Subject: RE: A/235/21/DOC - Land At Arundel Road, Angmering - revised Design Code

Please find attached the revised **Design Code Rev. C** for **A/235/21/DO** for Land at Arundel Road, Angmering.

Proposed land use plan

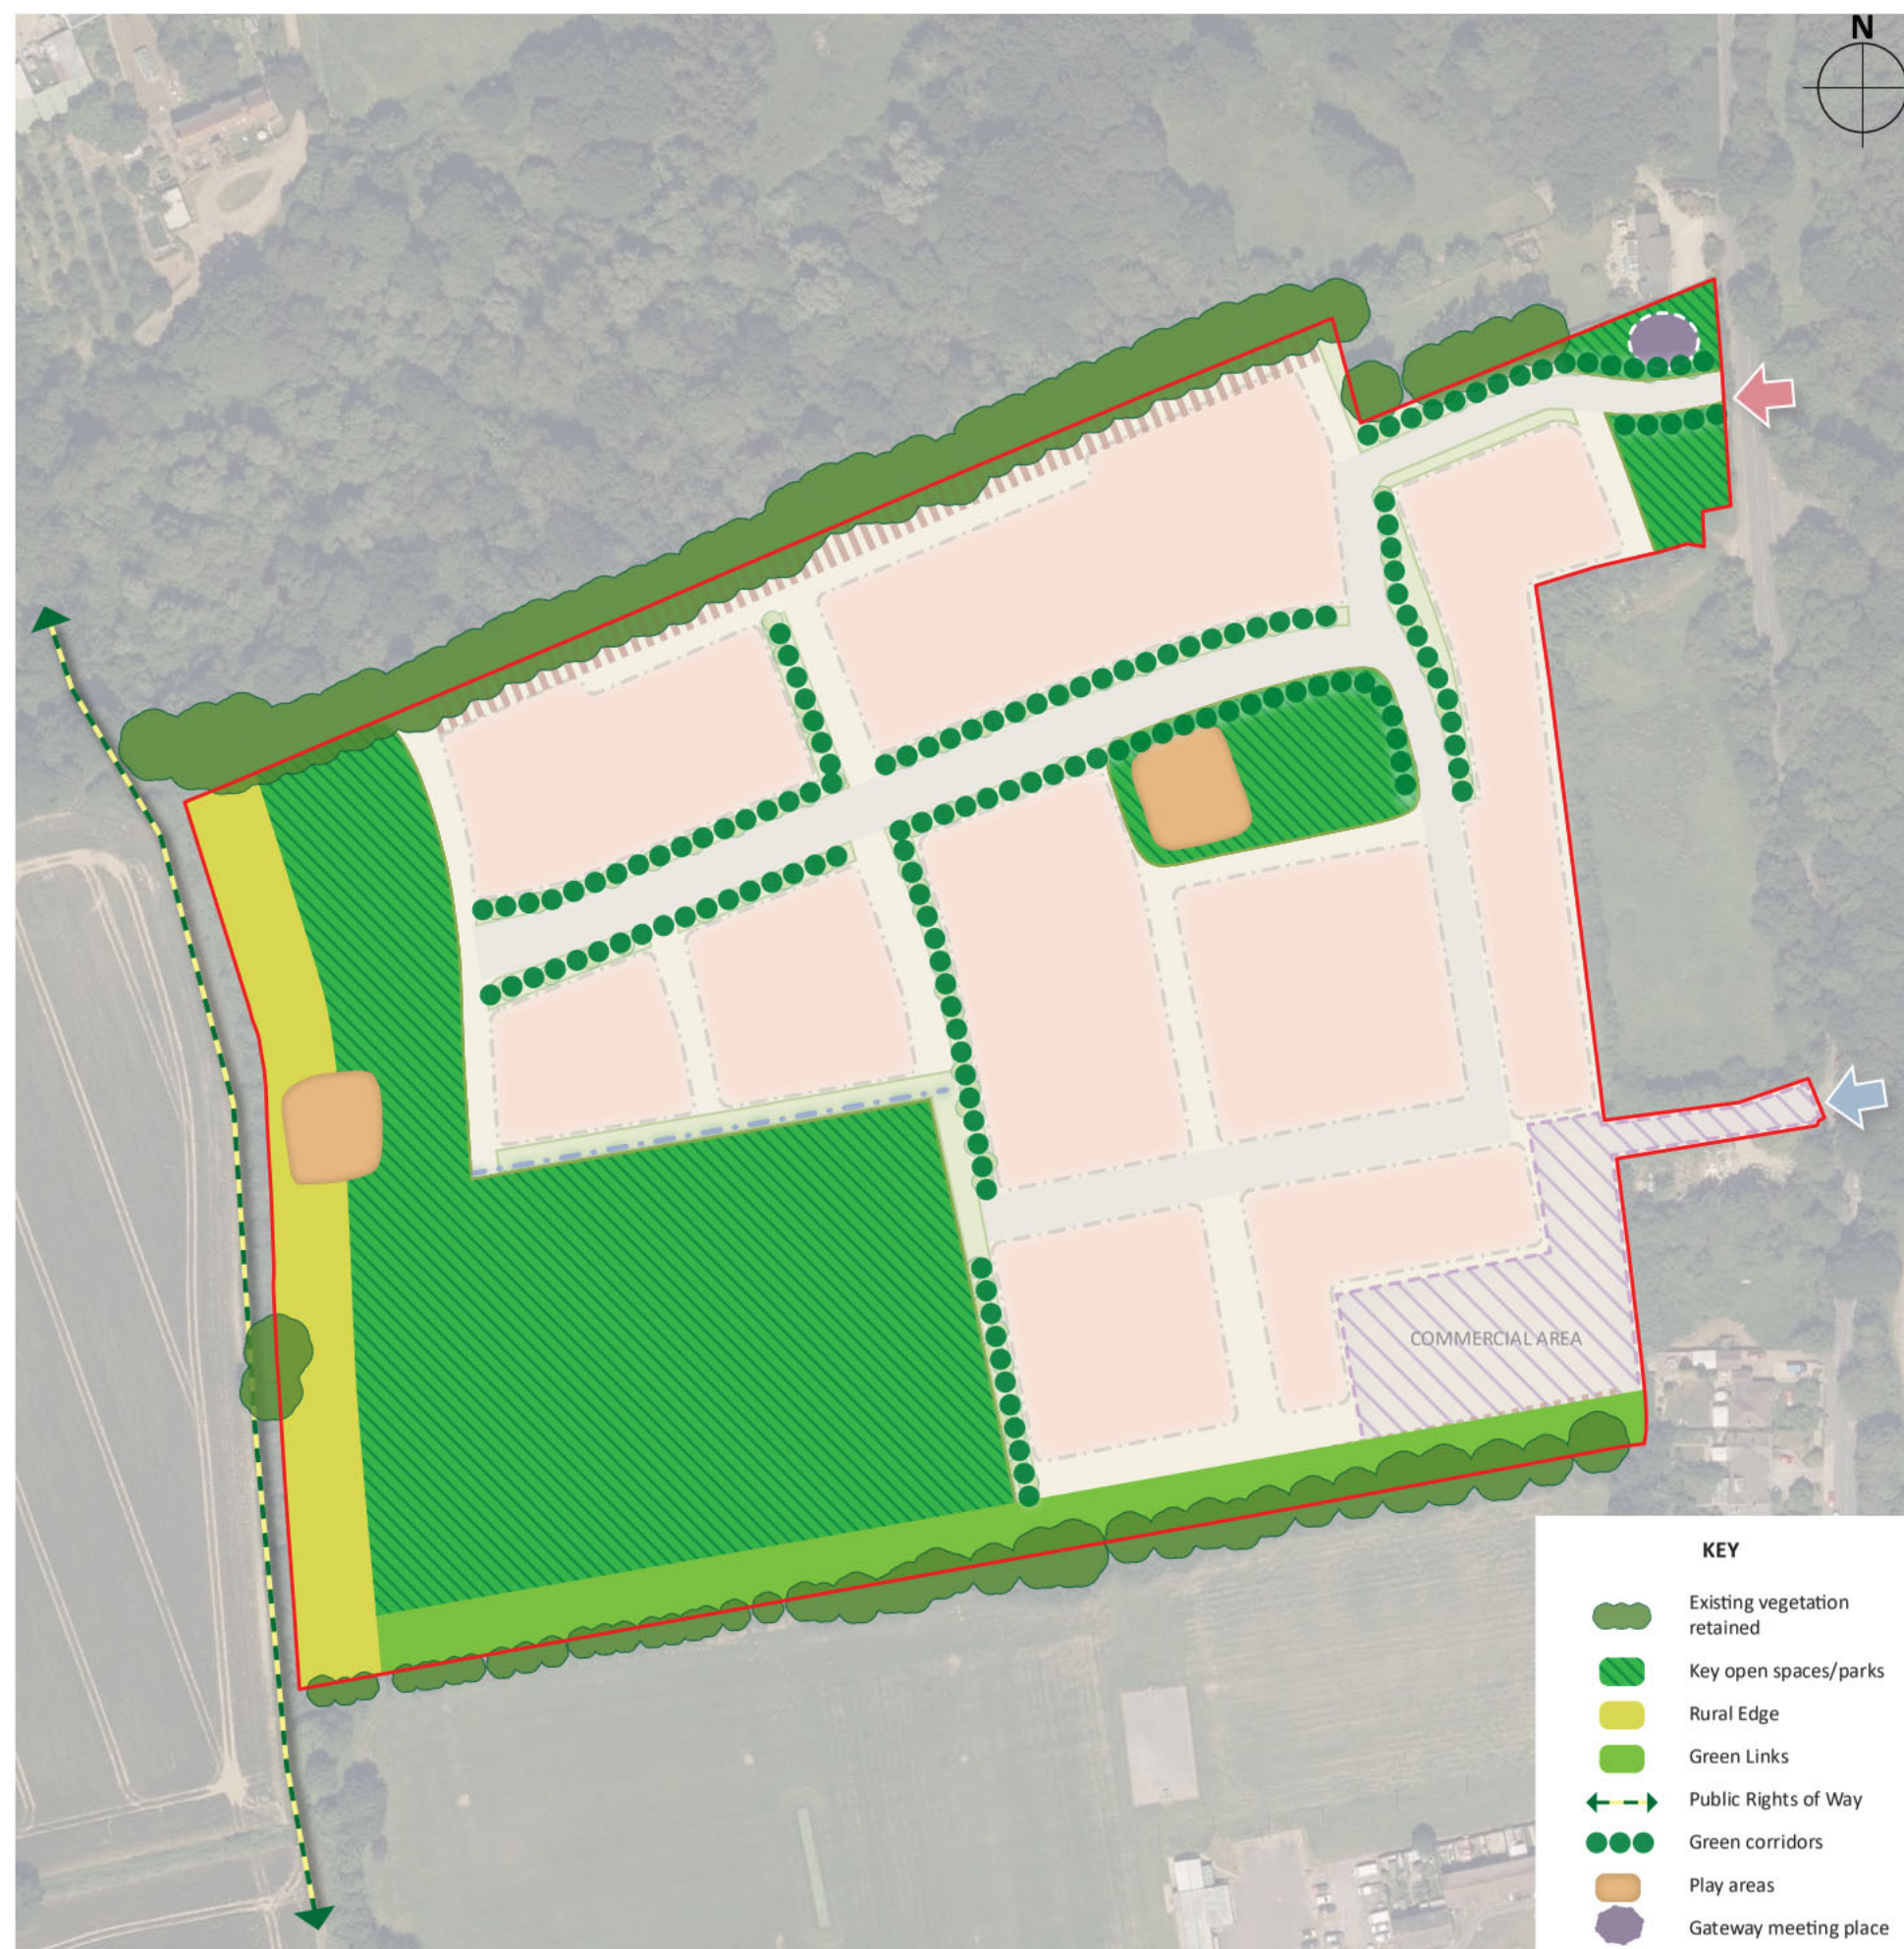
On page 23 and 24 there is some disparity on the land identified as the sports pitch land compared to page 22. They appear to show the same area of land as both green infrastructure (page 23) and as part of the key open space / parks (page 24). Although there is overlap between the definitions used clarity over the area of land to be used as sports pitches should be identified throughout. It is acknowledged that at the stage the DOC was submitted the pitch layout had not been determined, however to identify the land as anything other than sports provision is potentially misleading. In addition whilst the document refers to the area to the south as being sports pitches, it does not refer to this being transferred to ADC and being integral to the existing sports site to the south.

In order to be clear and open as to the future use of the sports pitch land, and as is set out in the S106, there should be reference to the land being transferred to the local authority and added to the existing recreation ground for future use for sports – there are several opportunities to reference this that have been missed. Anything else in the design code is potentially misleading to the community.

The document has been amended to reflect the comments which identify the green infrastructure and sports pitch and has made refers to the definition of the S106 this is therefore satisfactory. It has not addressed the transfer of this land to the local authority, however this may not be judged to be important as part of the design code and therefore this DOC.
